Medworth Energy from Waste Combined Heat and Power Facility

PINS ref. EN010110
Document Reference: Vol 9.20
Revision: 5.0
Deadline 5
June 2023

Schedule of Changes (Deadline 5)

**Figure 10.1i**  
**New Bridge Lane access design**

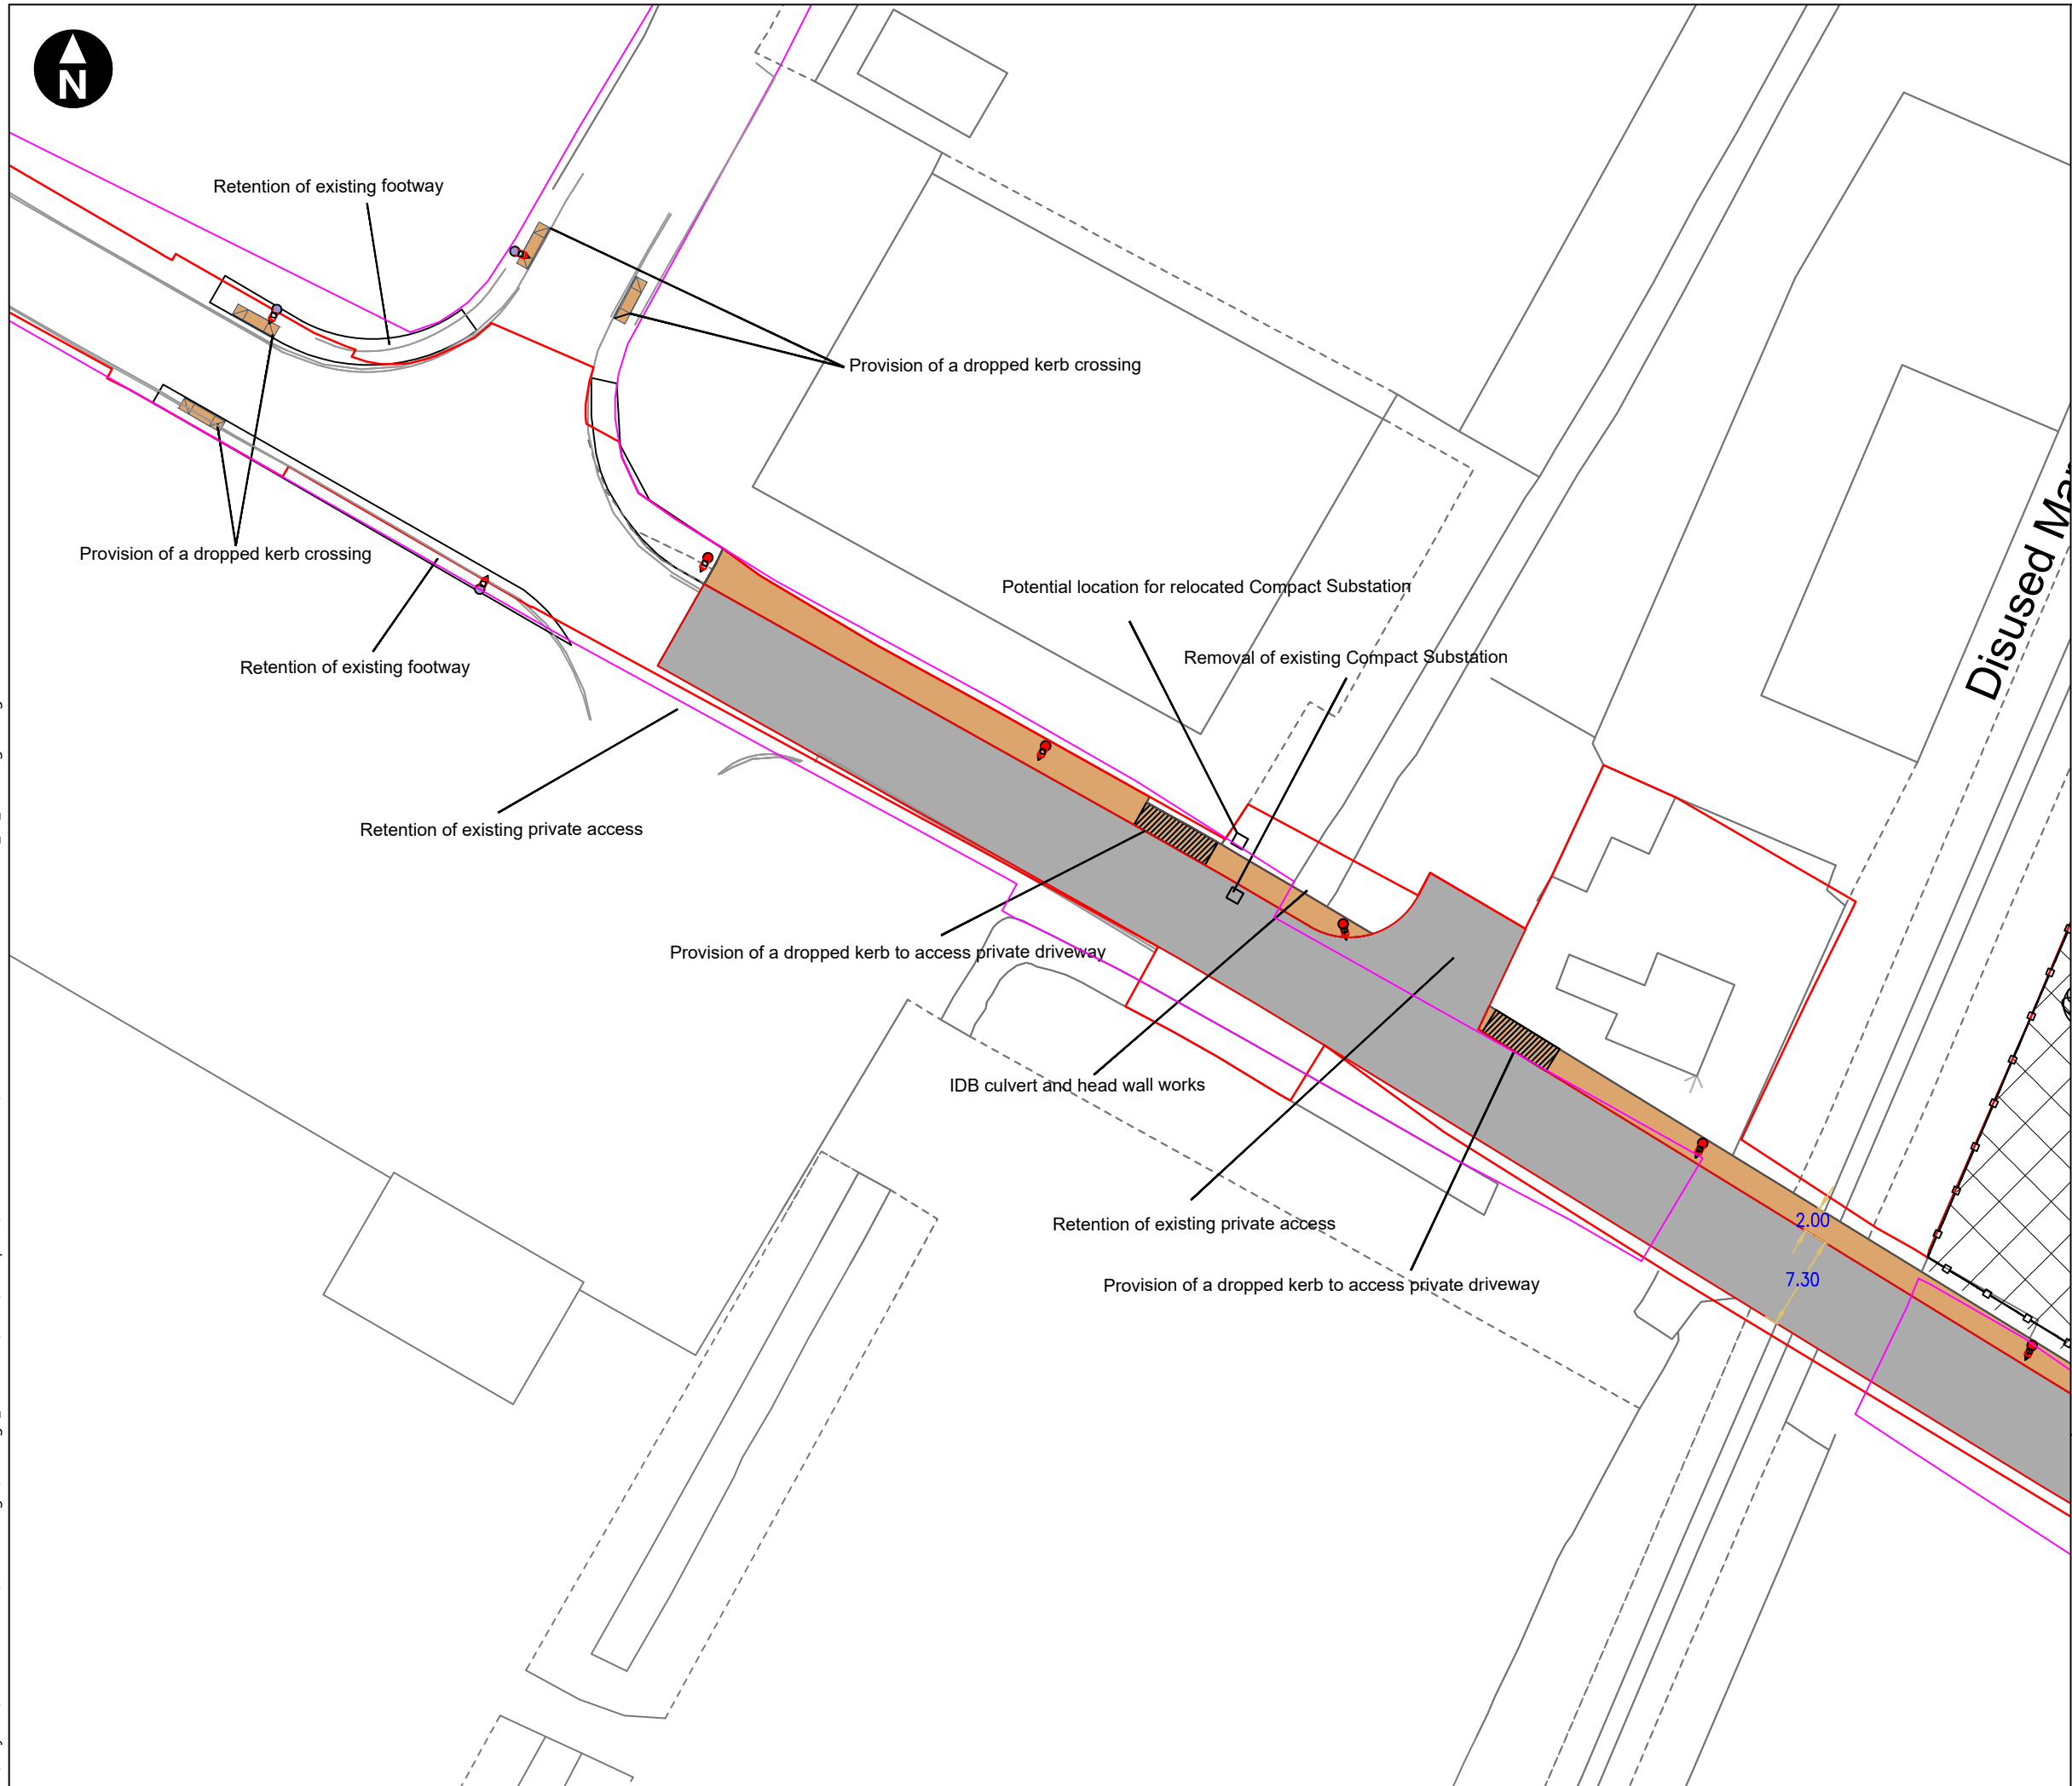
Volume 6.4 ES Chapter 6 Traffic	Additional drawings, Figures 9.2ii to show swept path of vehicle leaving New Bridge	CCC and FDC LIR paragraph 2.7.32 and 2.7.34 [REP1-074] .	Deadline 3	Rev 3

Document Updated	Change	Reason for change	Deadline submitted	Relevant Document version
and Transport Appendix 6A Outline (CTMP) [REP1-011]	Lane. Also Figure 10.3i – ii to show outline design for construction accesses into the CHP Connection Corridor from Weasenham Lane and accompanying swept path.			
Volume 6.4 ES Chapter 7 Noise and Vibration Appendix 7D Outline Operational NMP [REP1-012]	Reference to Applicant's intention to purchase 9 New Bridge Lane updated to confirm that the property has been purchased. Additional text added to 5.1.2 to include for the submission of a report to the relevant planning authority detailing the height, materials and acoustic performance of the acoustic fence to 10 New Bridge Lane for agreement ahead of construction.	CCC and FDC Comments on the Applicant's D1 Submissions (Outline CEMP) [REP2-031]. Outline Operational Noise Management Plan.	Deadline 3	Rev 3
Volume 6.4 ES Chapter 7 Noise and Vibration Appendix 7D Outline Operational NMP [REP1-012]	New paragraphs 1.4.8 and 1.4.9 to provide a commitment to the preparation of an Operational Noise and Vibration Management Plan for the Walsoken Substation.	KLWN Relevant Representation [REP2-028].	Deadline 3	Rev 3
